Application for approval of details reserved by conditions imposed under EP/63/16/PL relating to

Conditions 3 - Schedule of materials, 9 - Surface Water Drainage, 10 - SUDS, 13 - Construction

Bradbury Hotel Station Road, East Preston,

Arun District Council have decided to **REFUSE details reserved by condition for the following reasons:**

SURFACE WATER DRAINAGE LAYOUT

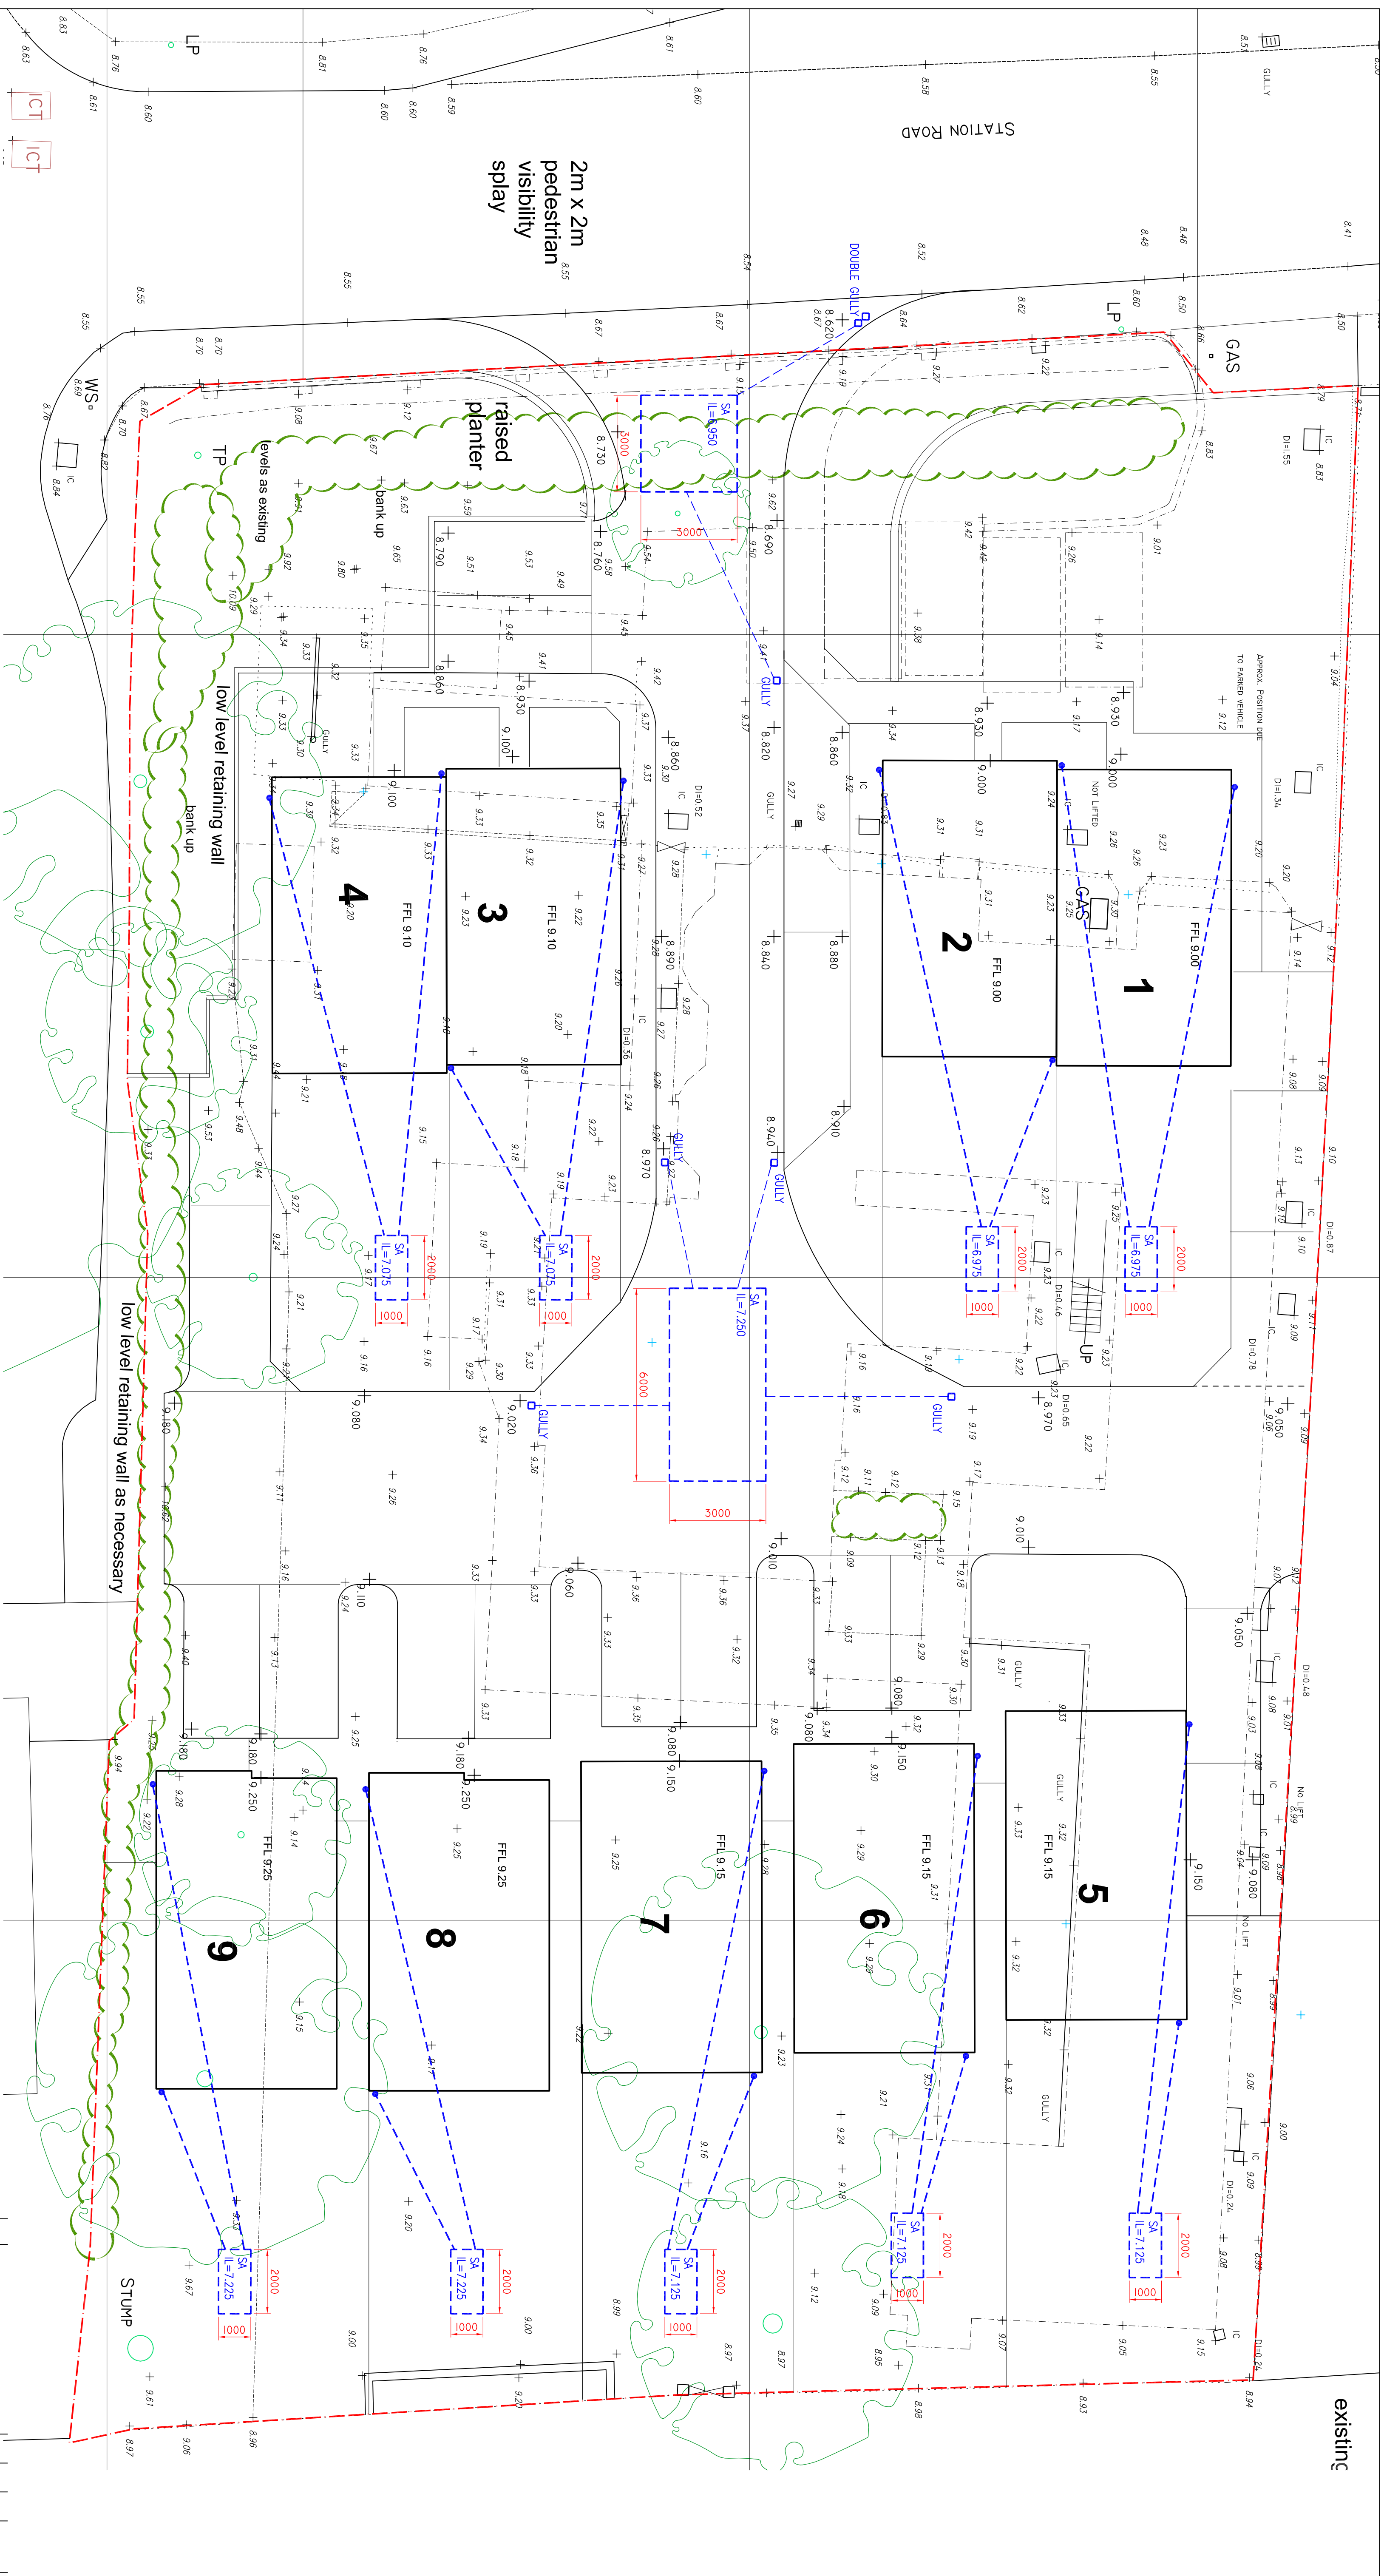
1. No winter groundwater data has been provided. This is critical to the design.
2. Provide the date of when the percolation tests were undertaken, together with a plan showing their locations.

Confirm at what depth (ie. water fill level below ground level) each test commenced.

4. The storage calculations provided appear to relate to concrete ring soakaway design, an insufficient design

storm event and incorrect impermeable areas. Calculations for the 1 in 10 and 1 in 100 year (+30% Allowance

for climate change) are required for each soakaway structure.

5. Why is permeable paving for the highway areas not being considered? This is the preferred method for surface

6. Additional silt interception is required in the form of catchpit manholes. These are required on all entries to

soakaways and also allow a means to clean the upstream pipework.

7. Full constructions details (ie. drawing) of each soakaway structure, gullies and catchpits, etc., are required.

8. Specify pipe gradients/invert levels on all pipes connecting to soakaways.

9. Specify gully outlet invert levels and finished levels for the grated cover. This item may be affected by item 5 of
